Please ask for: Ms Iqraa Malik
Email: iqraa.malik@terraquest.co.uk
Telephone: 0121 234 1390
Our Ref: LU/319/21/HH
Your Ref:
Date: 11th October 2021

Application for Planning Permission for Works or Extension to a Dwelling

Development: Erection of single storey side and rear extension following the demolition of existing rear conservatory
Location: 97 White Horses Way Littlehampton BN17 6NL

Proposed Ground Floor

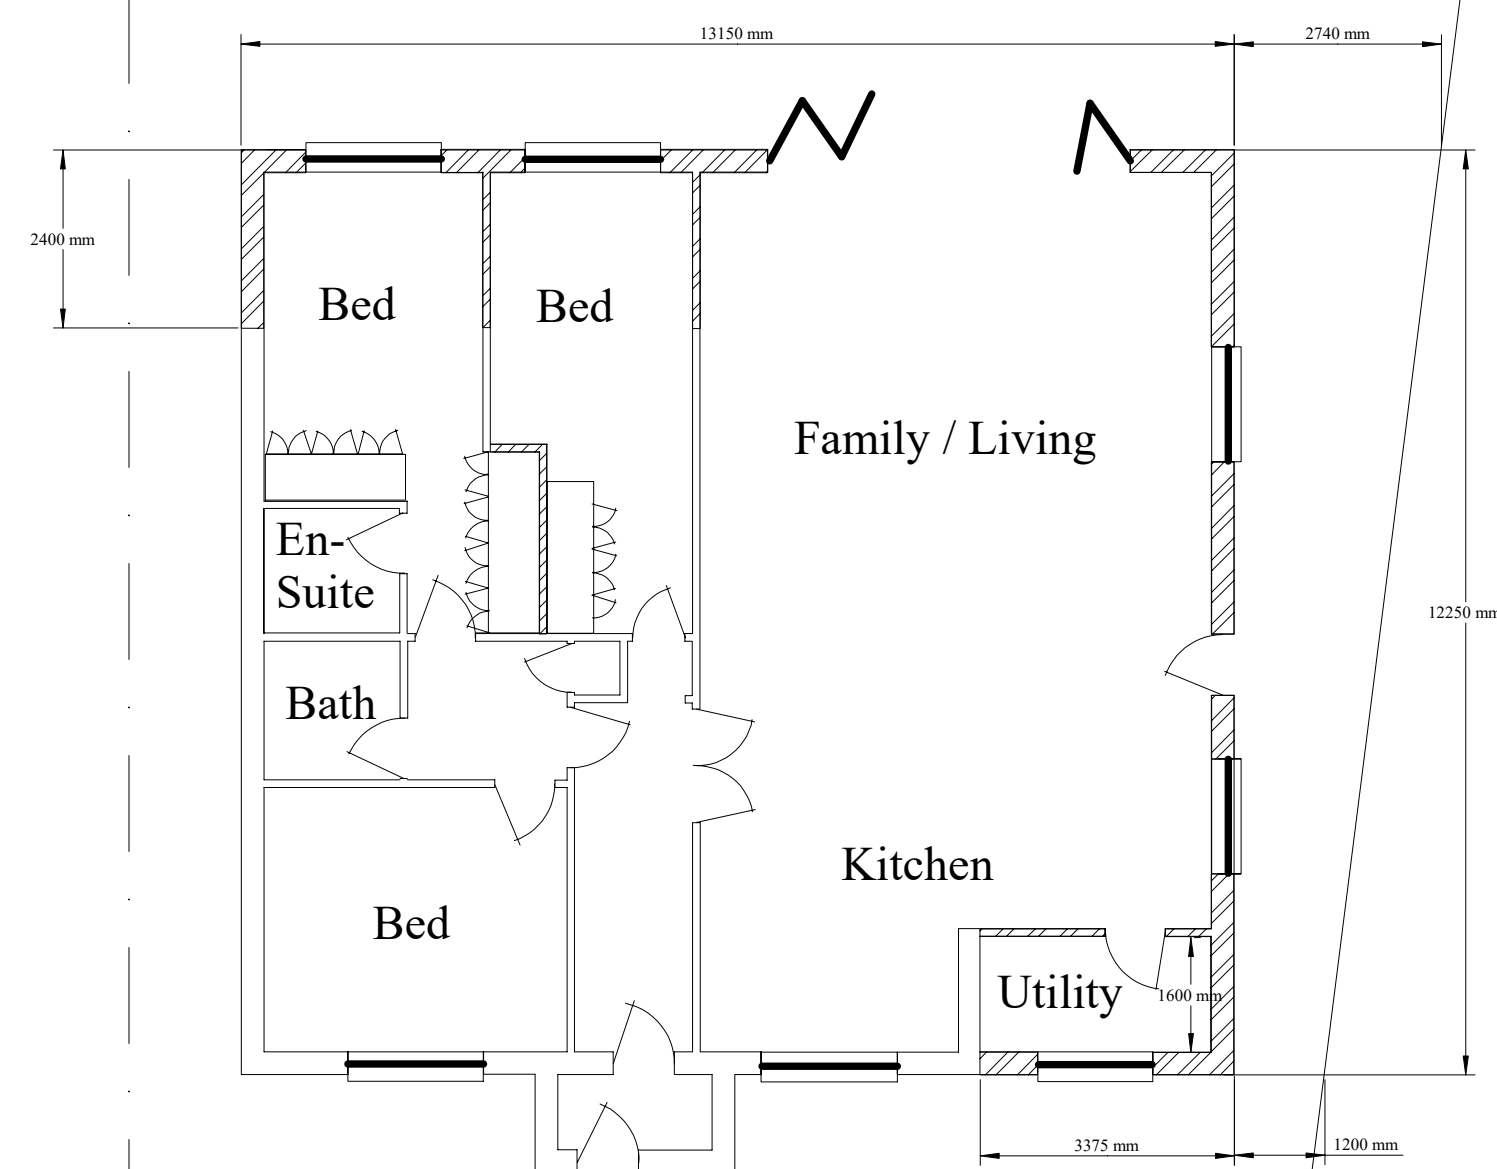
The door on the proposed ground floor plan is missing from the proposed south elevation. Please review and amend.
